**From:** Build View [REDACTED]  
**Sent:** 12 November 2021 14:16  
**To:** Kathryn Welch  
**Subject:** Re: R/222/21/HH - REP Letters  
**Attachments:** 42 Pigeon House Existing and Proposed LPA Rev3.pdf

**From:** [REDACTED]  
**Date:** Thursday, 28 October 2021 at 14:28  
**To:** kathryn.welch@arun.gov.uk <kathryn.welch@arun.gov.uk>  
**Subject:** R/222/21/HH - REP Letters

A :: **Proposed First Floor Plan**
03 scale: 1:100

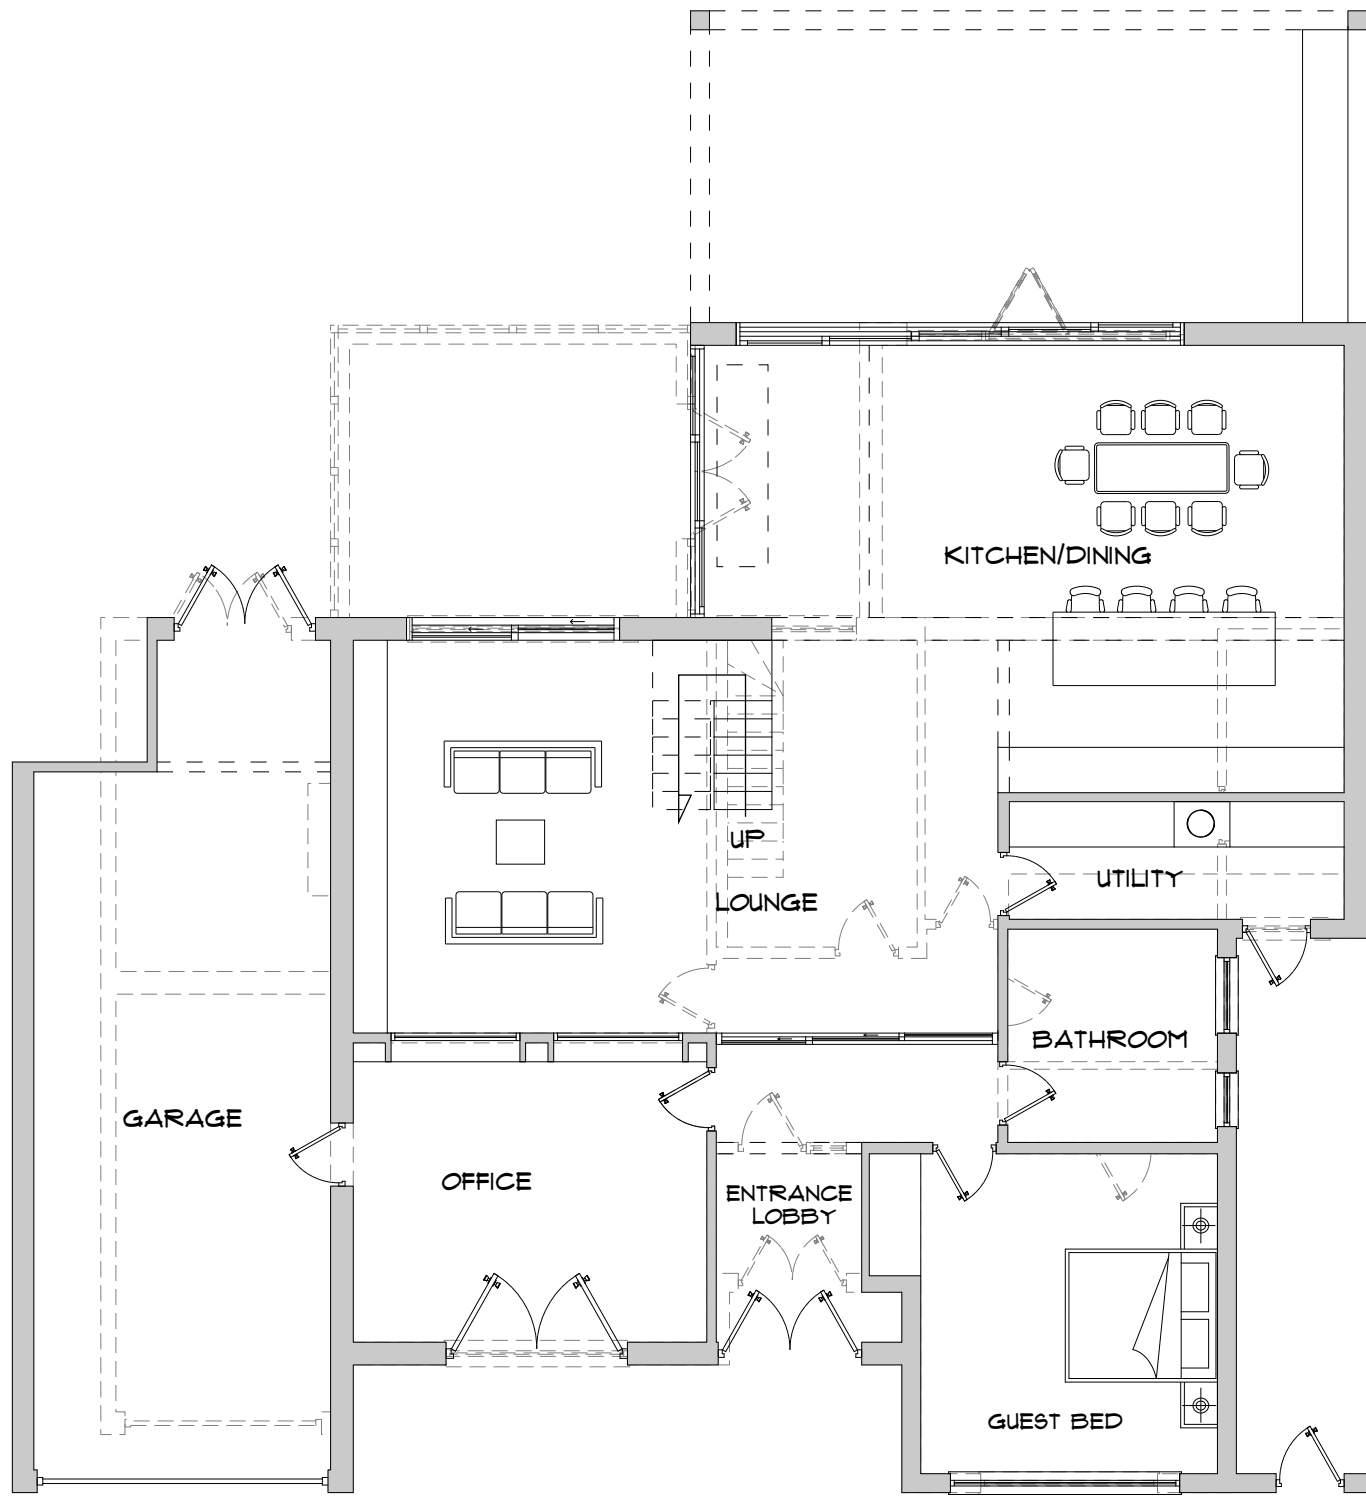
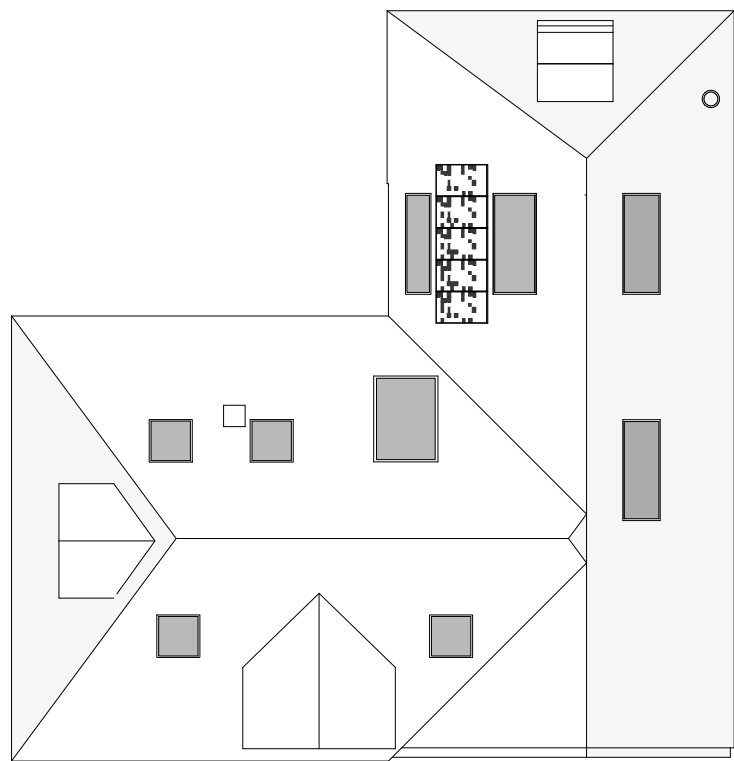
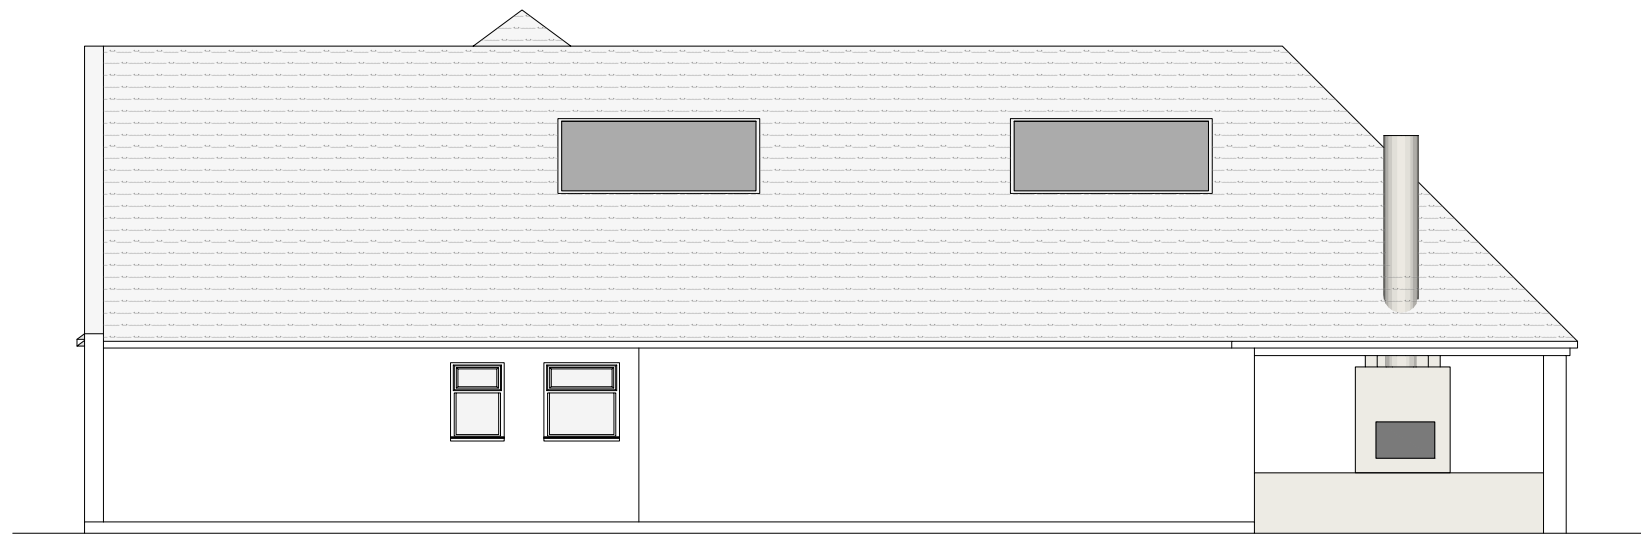
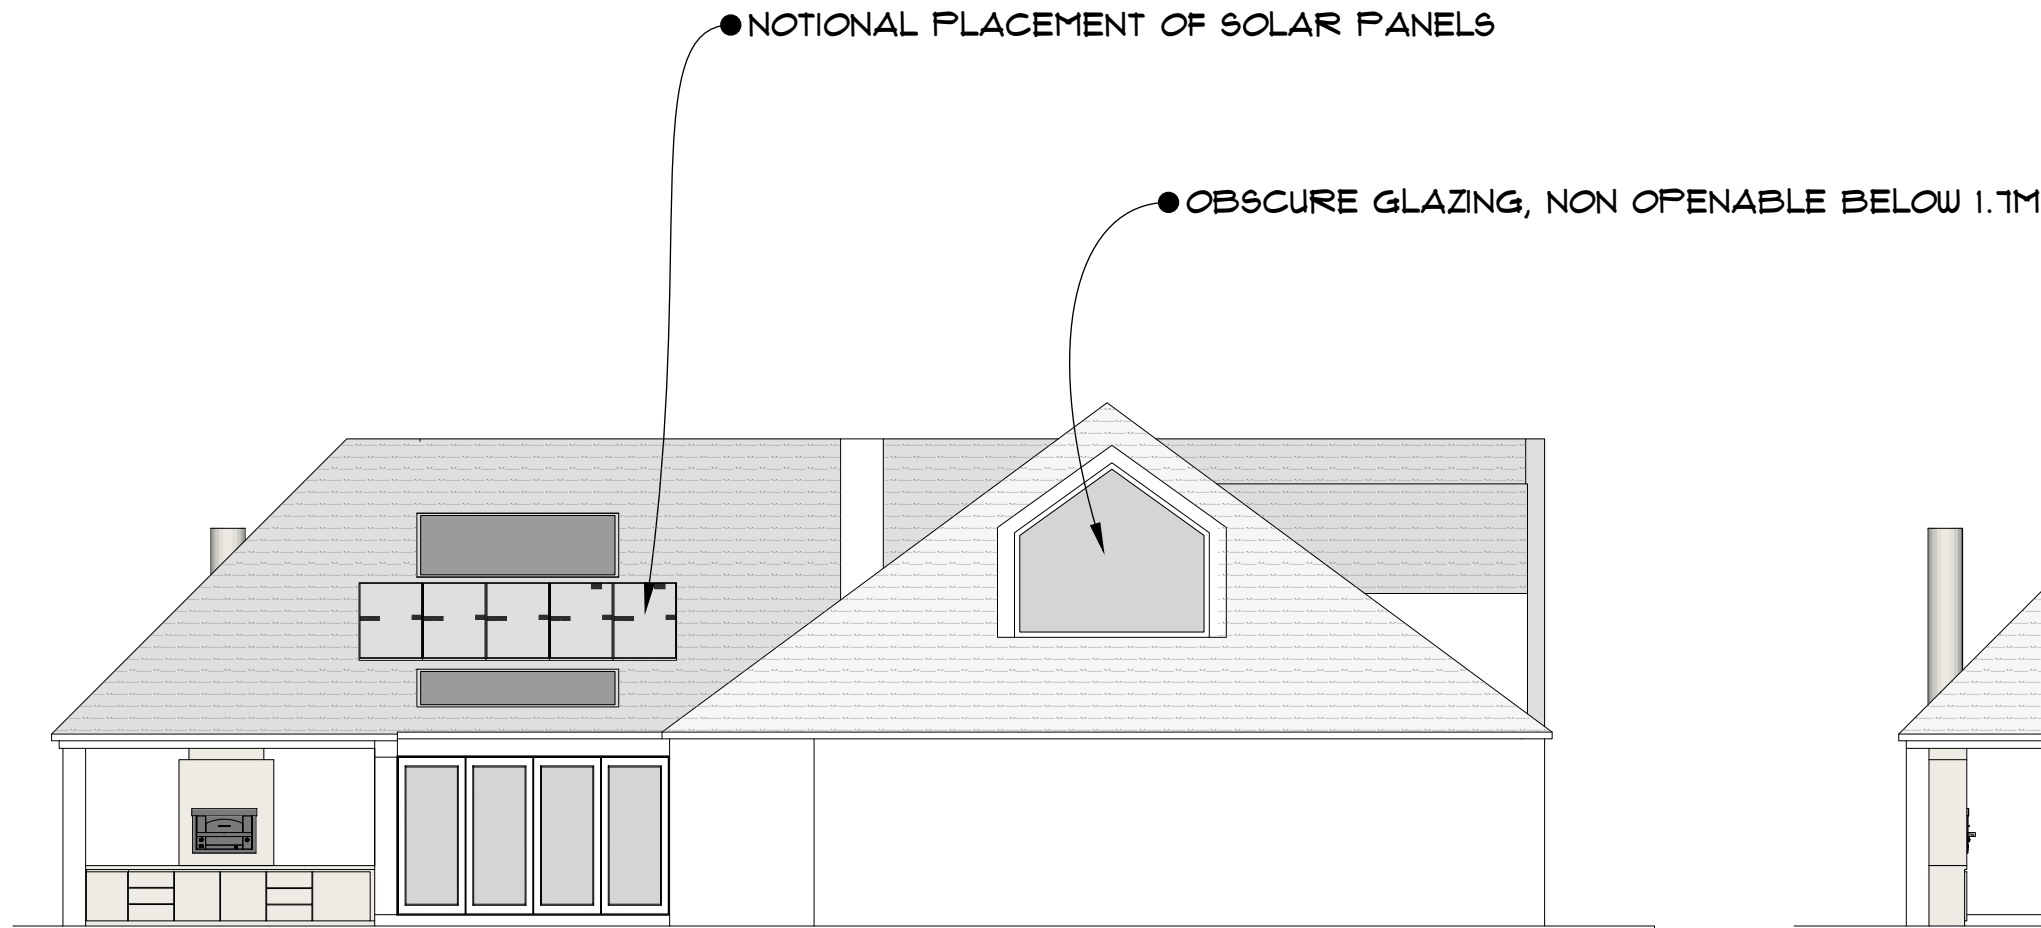
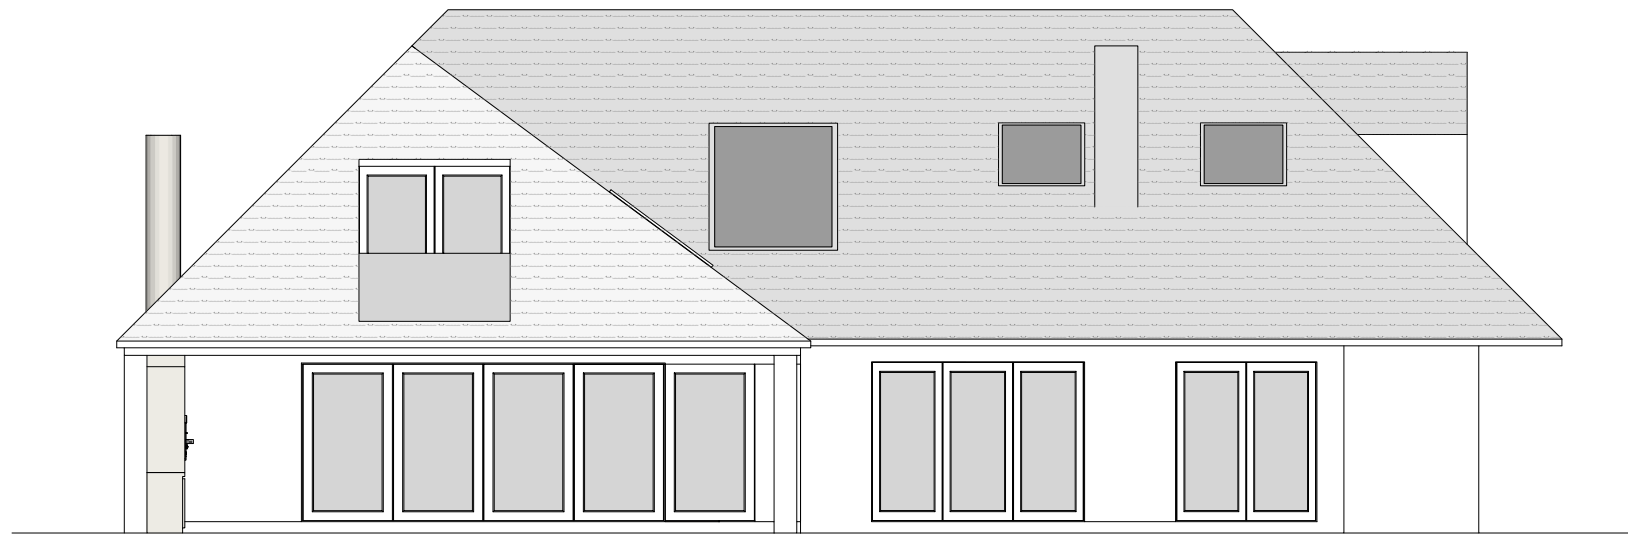
This dormer has been presented with non-openable glazing below 1700mm and is presented with obscured glass. There is no loss of privacy and or the chance of any overlooking which may be considered unneighbourly. The opposing dormer also has obscure glazing.

- 1, The boundary has been taken from the ordinance survey maps, OSGrid Ref: TQ 610 172.
- 2, All Windows to the North are Velux type windows 1700mm from the FFL and as such do not present any overlooking issues and are permissible under PD. The proposed balcony is recessed within the roof structure with the glazed balustrade within the hip of the roof, thus making any attempt to overlook physically impossible.
- 3, As understood by the case officer during the pre-application phase, care has been taken during the design considering any adverse effect on the neighbours. The pre app ref: PAA/92/21/
- 4, The out door kitchen chimney has notionally been included, this is for BBQ's during the summer only and has been included to REDUCE any ad hoc smoke effect on any neighbour as and when my client has BBQ's.

All roof lights are Velux roof windows and as such would fall under PD. The glazed eastern window over the stairs is non openable. The balcony and glazing has been acknowledged within the pre application received.
